Director Infrastructure Projects
Department of Planning and Environment
Major Projects Assessment
GPO Box 39
SYDNEY NSW 2001

PROPOSED NORTHCONNEX M1 / M2 TUNNEL PROJECT - Application Number - SSI 13_6136

MOTORWAY OPERATIONS COMPLEX - SOUTHERN VENTILATION FACILITY - SECTIONS
M1-M2-5000-DR-JD-0525

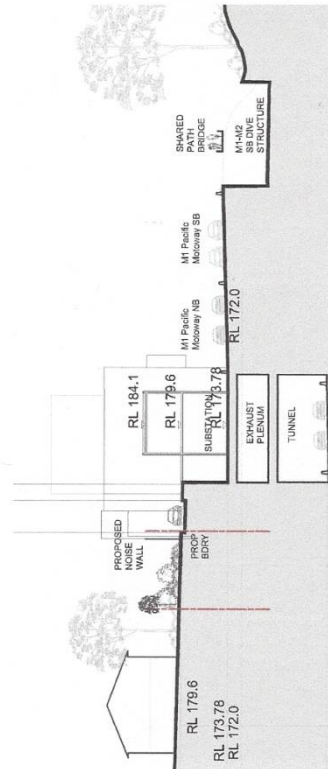
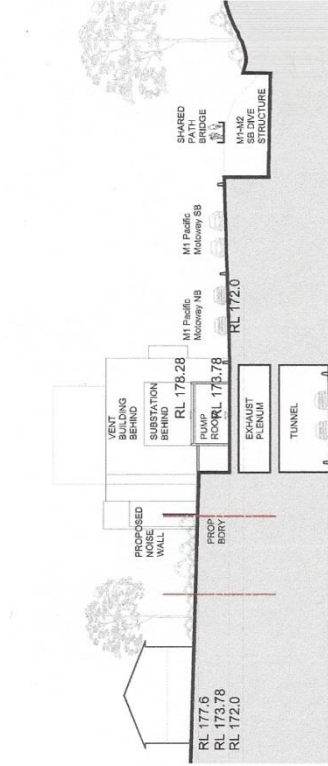
1. The Environmental Impact Statement (EIS) does not show any connection between the ventilation stack and the southbound tunnel which is 250 metres away. Will the polluted air be allowed to flow like an invisible sewer through West Pennant Hills, North Rocks, Carlingford and Beecroft?
ACTION: Provision of diagrams and detailed description of what ventilation is proposed for the southbound tunnel at the Southern Interchange. We would like the opportunity to lodge further submissions once that has been provided.
